Engineers Comments Regarding Surface Water Drainage

Application Reference:	WA/50/25/DOC	Reviewer Reference:	ADC/EXT4
Planning Officer:	Amber Willard	Date of Review:	11/12/202
Site Name:	Fleurie Nursery Lake Lane Barnham PO22 0AL		
Application Description:	Approval of details reserved by condition imposed under reference WA/75/20/PL relating to condition number 3 - surface water drainage scheme, condition number 4 - surface water drainage system and condition number 7 - surface water drainage scheme.		
Assessment Number:	2 of 2

Drain installation
details.

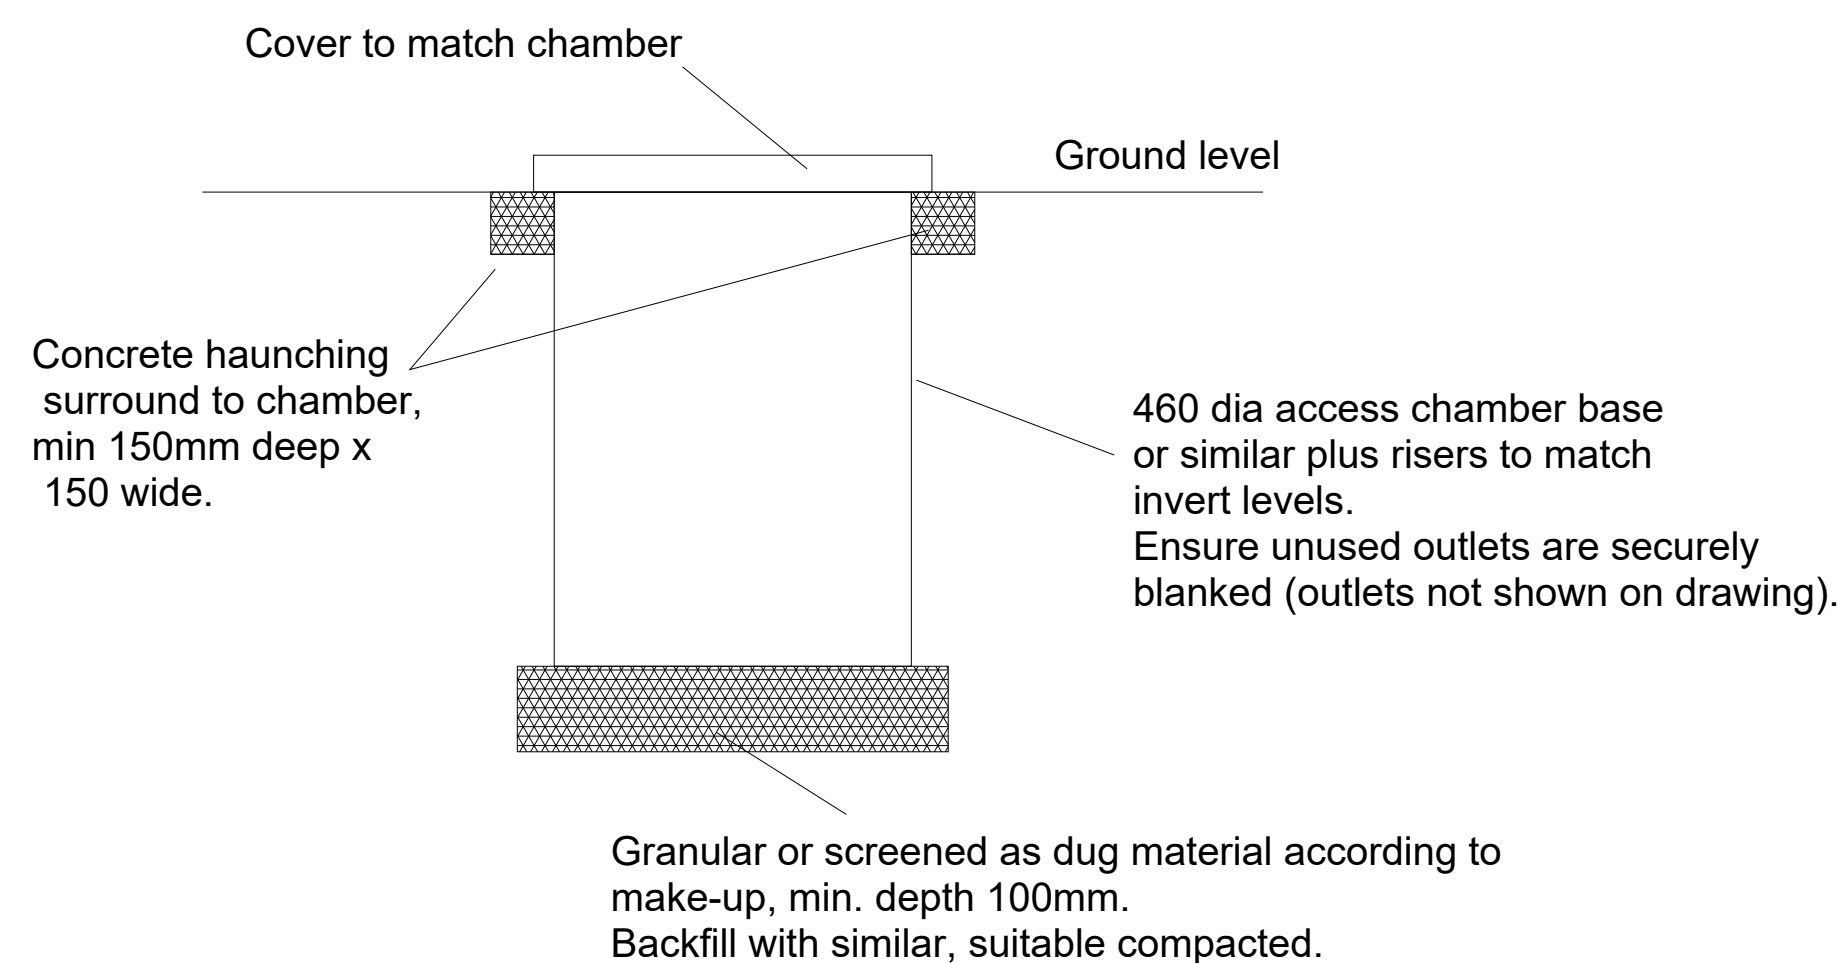
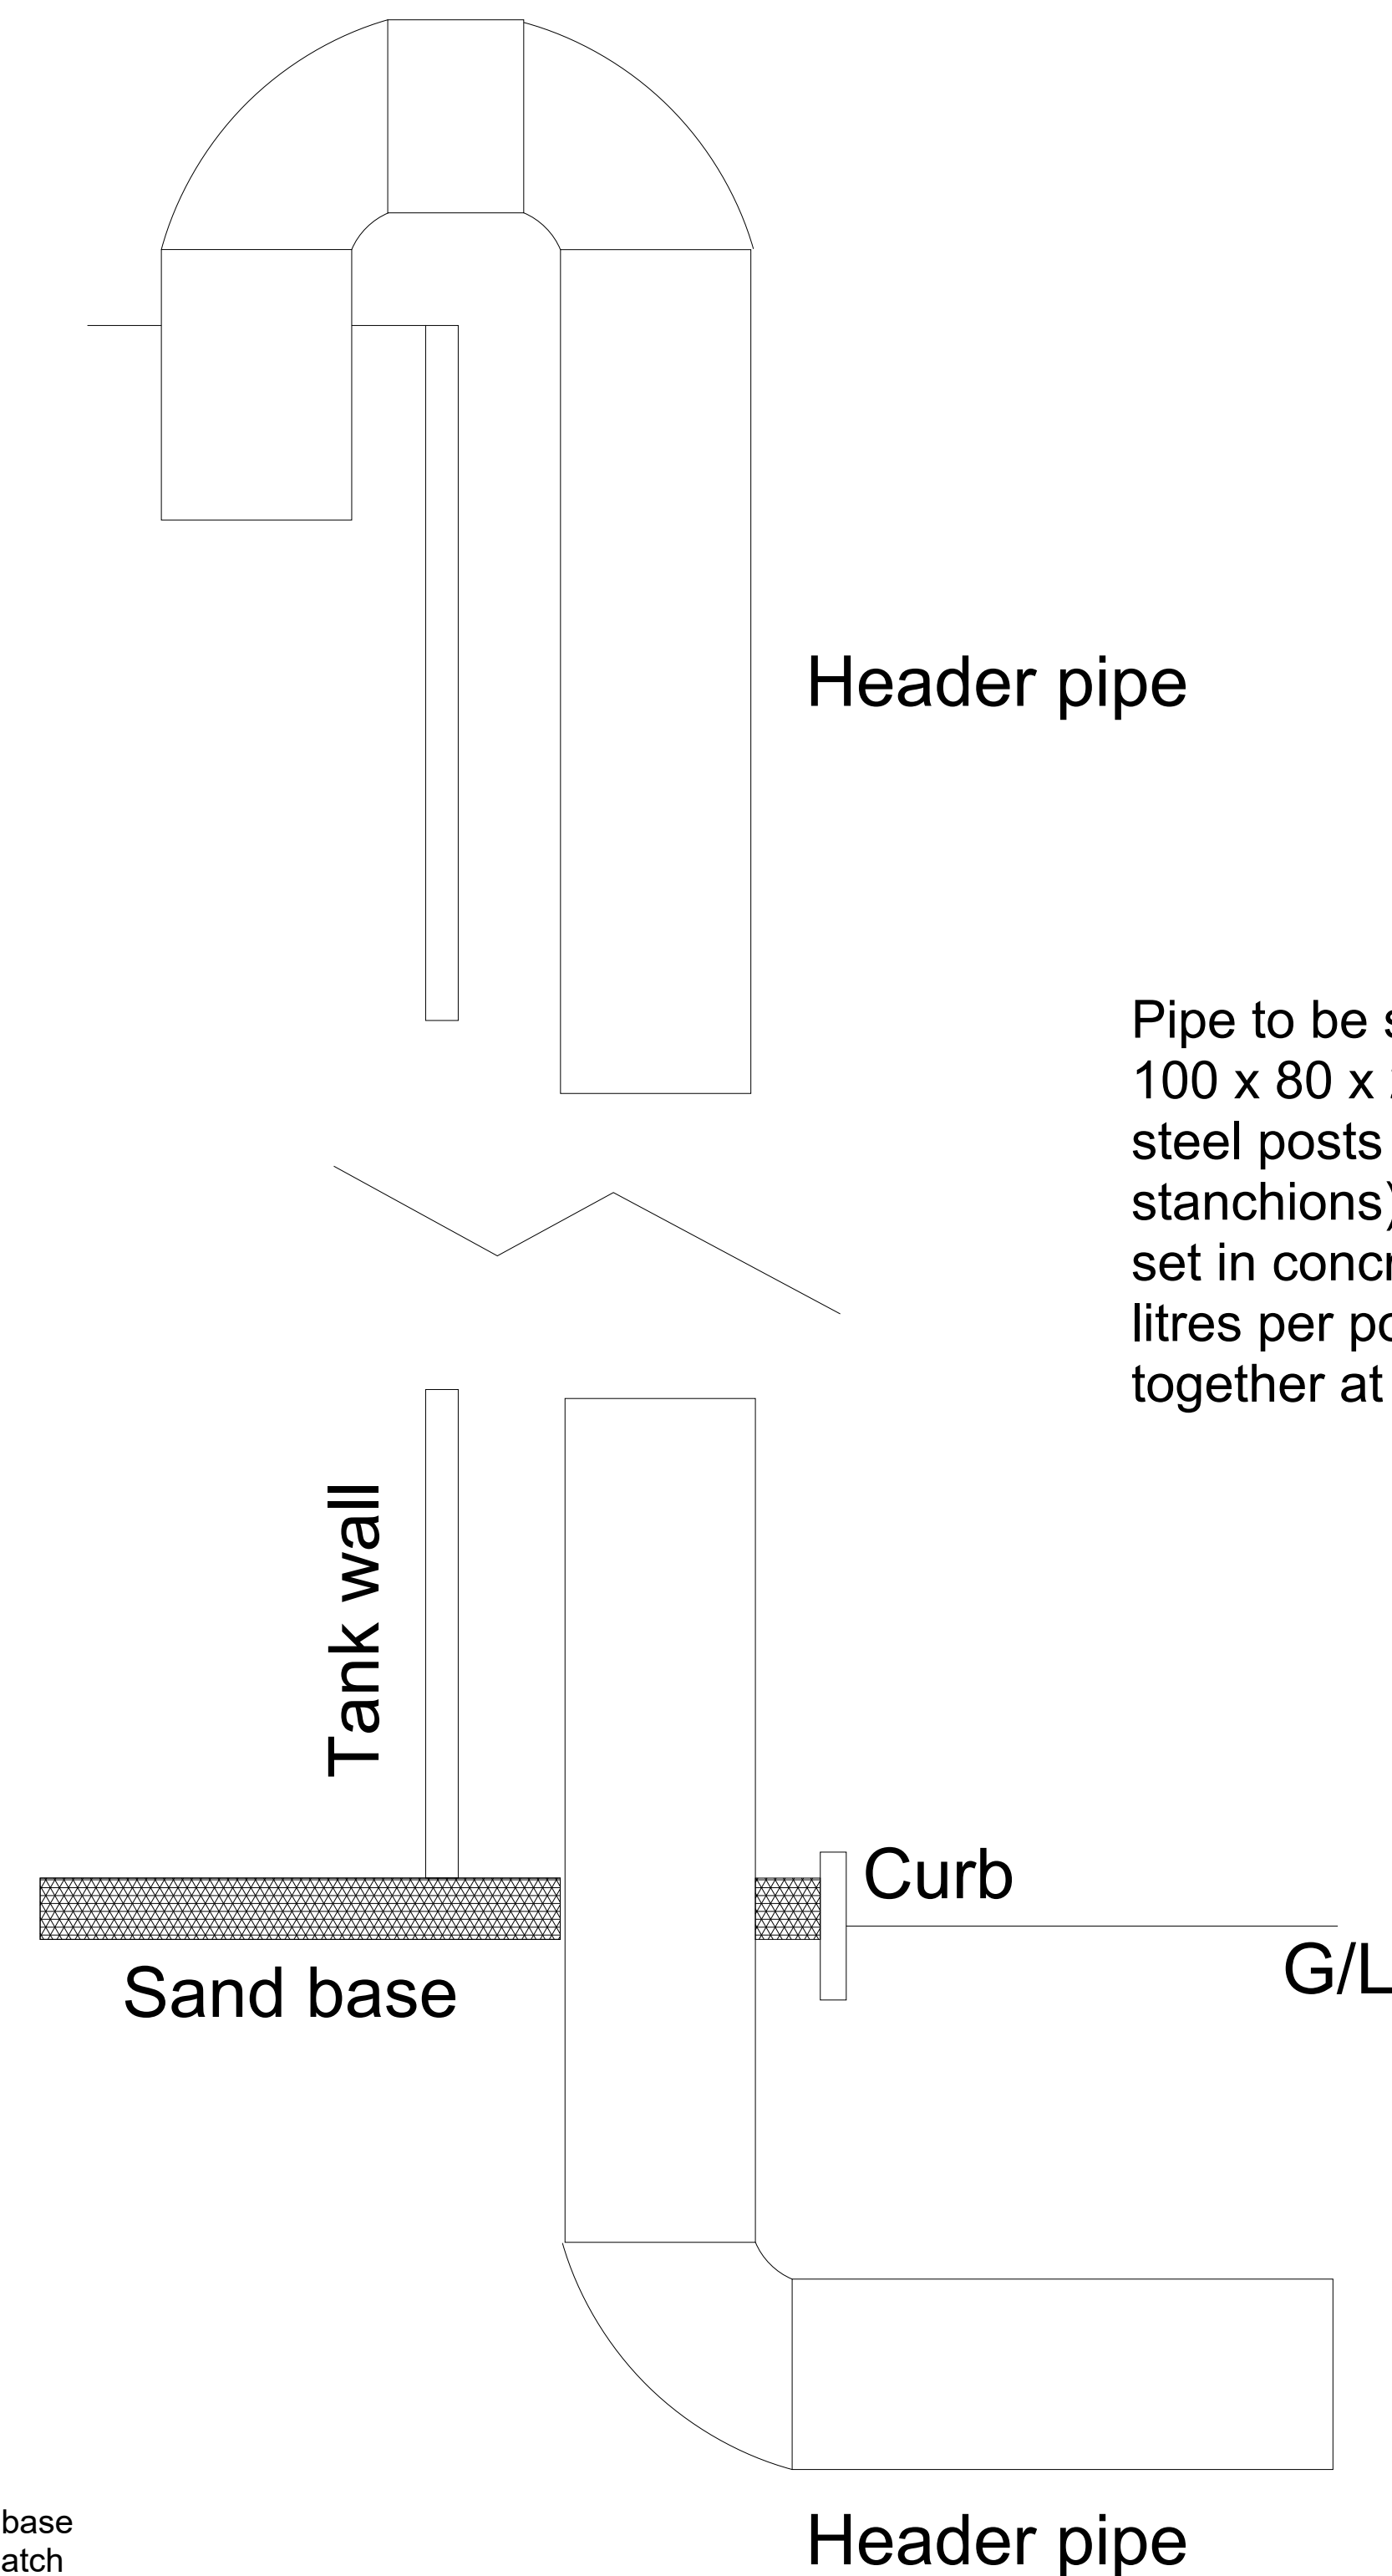
3.	The long sections provided are too basic and unclear and do not appear to provide any details on chamber locations, depths of chambers etc.. nor is there a clear correlation to the drainage layouts	e presume that this relates to drawing "Invert levels", and have added additional items that hopefully render it clearer. If it refers to a different drawing please identify it for us. This drawing has now been expanded out into 5 drawings for clarity. Pipe and invert #1 - overall site layout naming the blocks as detailed in #2-5. Pipe	As per item 1, the information submitted is still insufficient, please refer to the Arun District Council website for the designer checklist on the minimum information required to be submitted in support of the discharge of the surface water drainage conditions https://www.arun.gov.uk/designer-checklists

and invert #2 - North greenhouses (which are the only ones to feed the north outfall) Pipe and invert #3 - South east greenhouses (which feed the south outfall) Pipe and invert #4 - East greenhouses (which feed the south outfall) Pipe and invert #5 - South west greenhouses (which feed the south outfall) See also "layout" drawing. See also "Drain installation details" drawing.

East exceedance.
Bund area and level

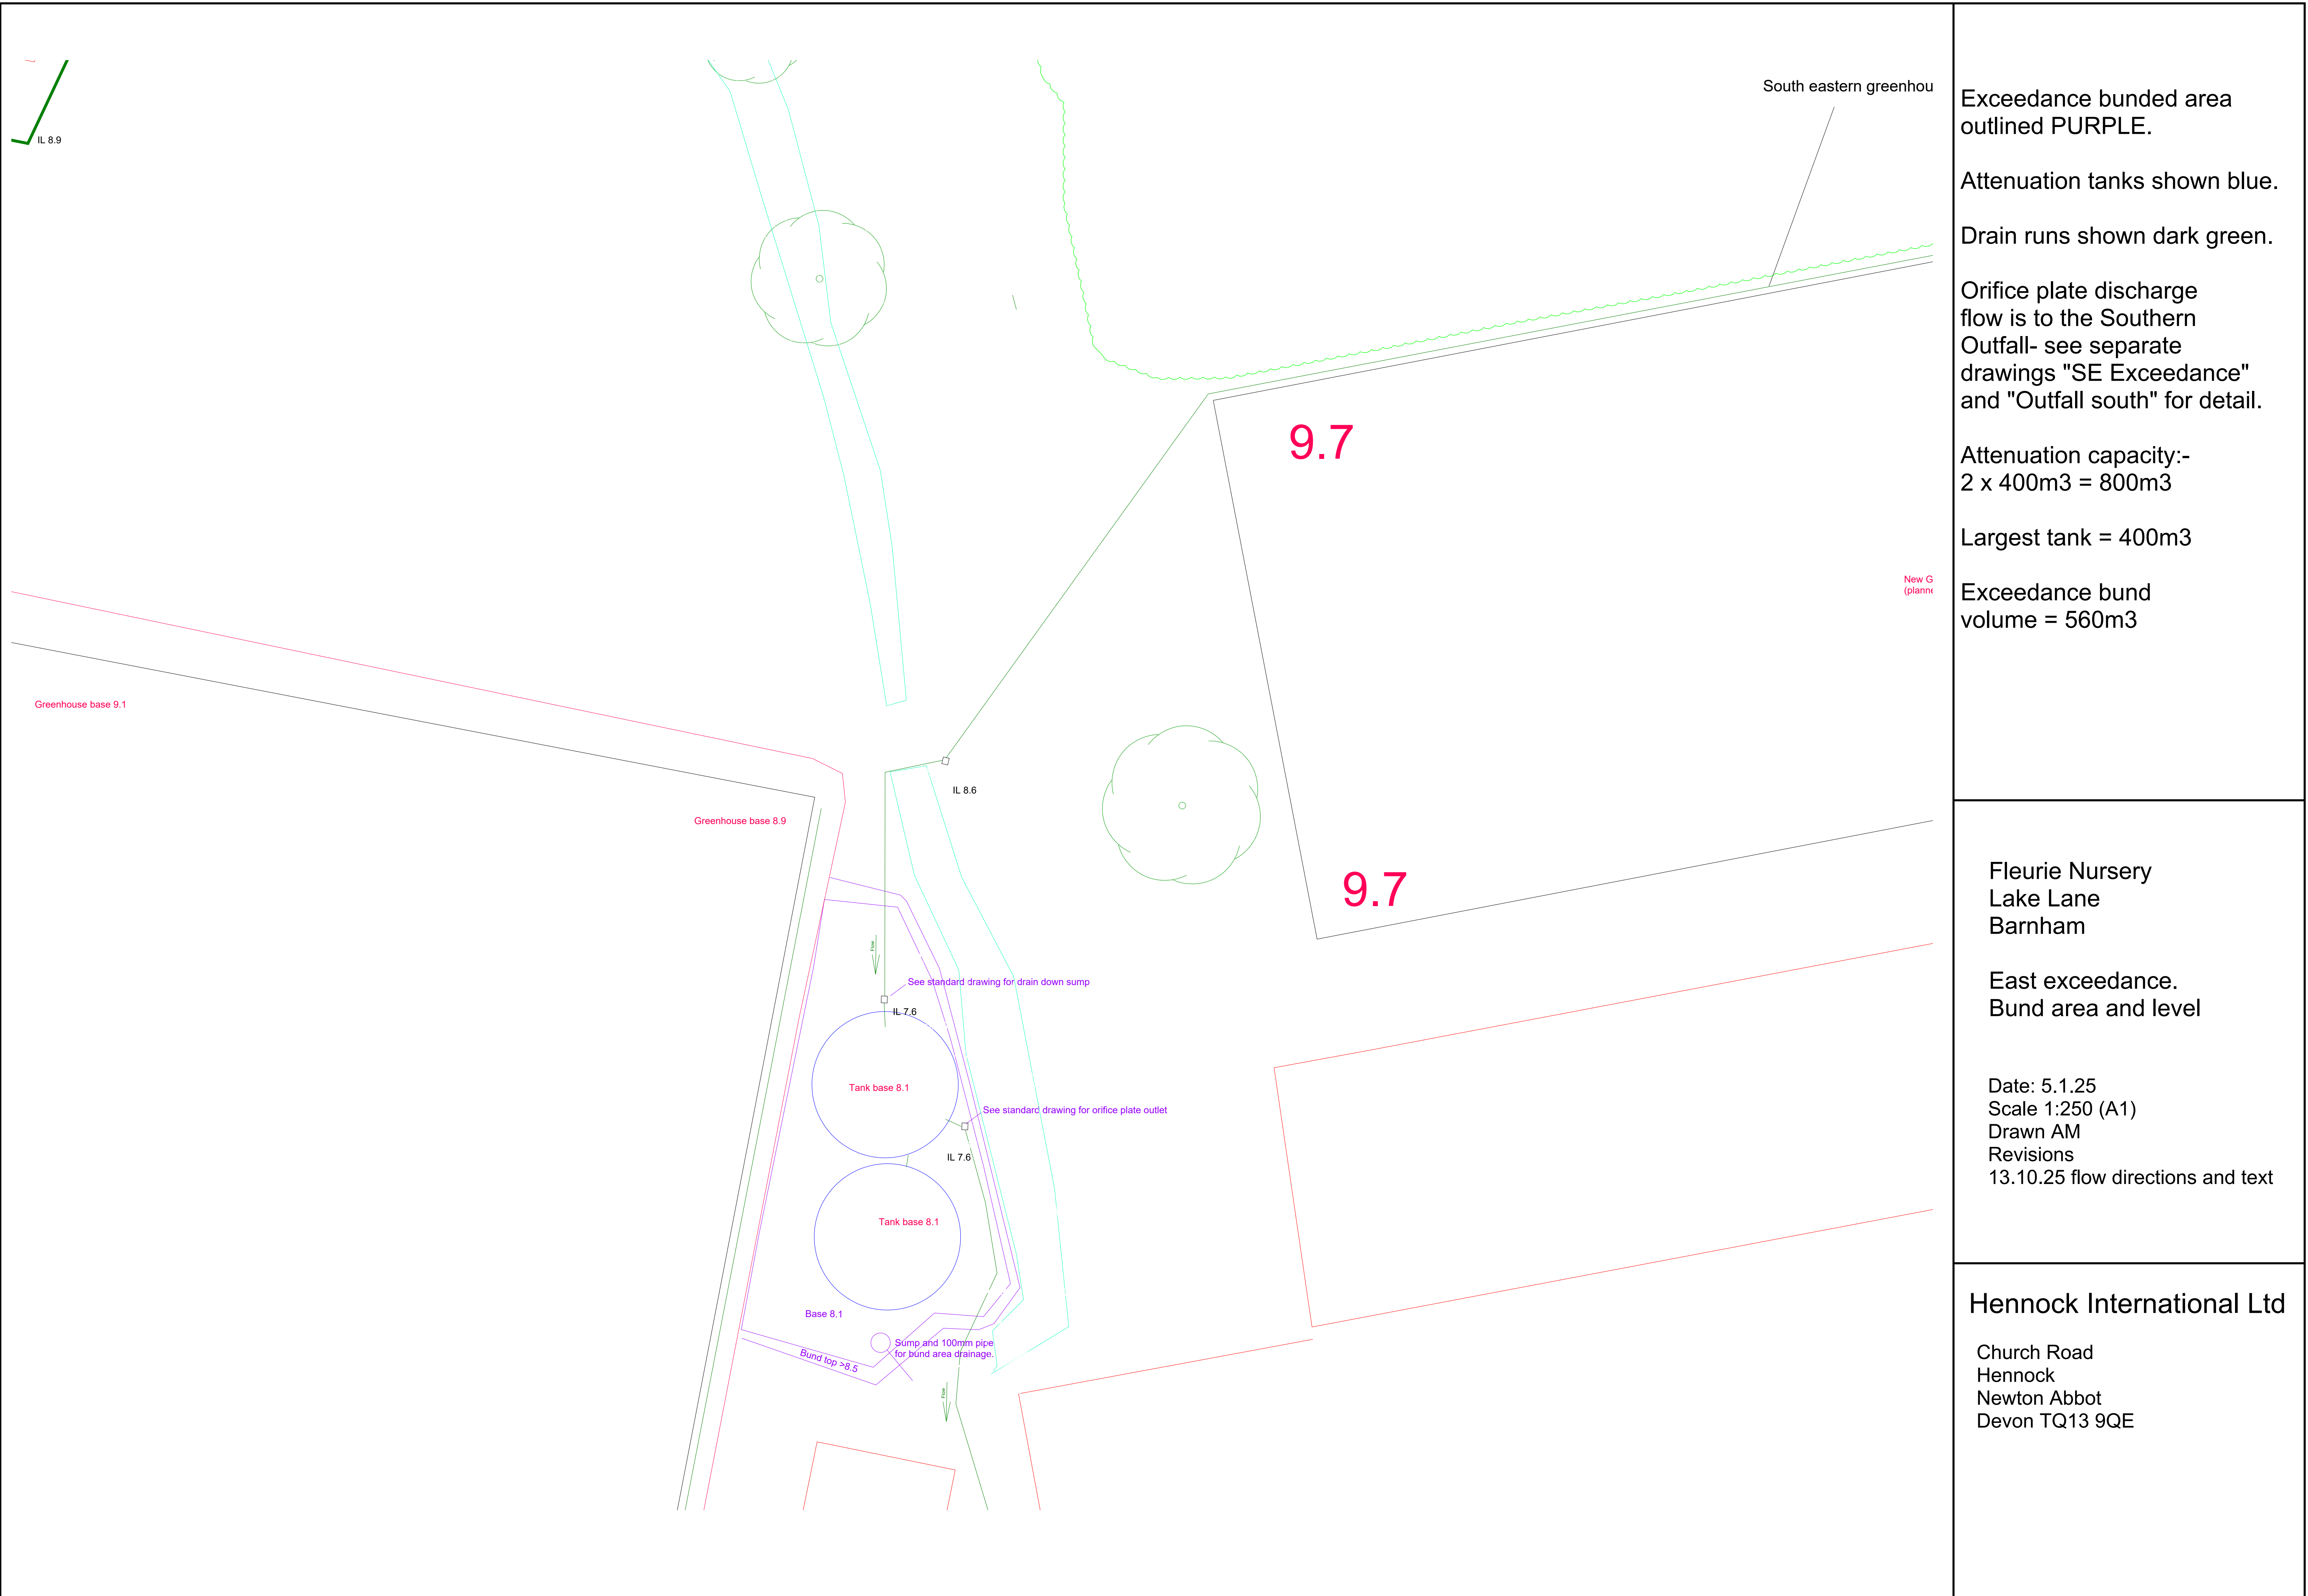
visible flow into the attenuation tanks. Experience and reason also dictate that for a large bore pipes with solely clean water in large volumes going along them blockages are not likely to occur. Self propelled CCTV inspection devices can reach 200m from entry, and none of our runs are as long as this so this is not a problem if required.			
5	The exceedance flow layouts are unclear. Further information is required on areas of temporary ponding, flow directional arrows etc...	The exceedance in this case is to cater for (a) an event greater than the system capacity (which makes it greater than the 1:100 years event plus 40% for CCA), and (b) catastrophic failure of 1 of the tanks. It is based on impoundment, using the natural levels and earth bunds. This approach has been acceptable to date. The volume required is based on that of the largest tank in the group, and the volume available by the design to achieve this is simply the depth over the area (using battered banks) minus the footprint of the remaining tanks. The	The design and exceedance flow layouts need to be based on either proposed level and or consideration to existing topographic level information as well. Currently the drawings provided appear to have very limited level information provided. Without this information it's unclear on the final direction of exceedance flows

volumes are now shown on the drawings. The required alterations to the exceedance drawings have been made, see drawings "SE exceedance", "SW exceedance", "E exceedance" and "N exceedance".
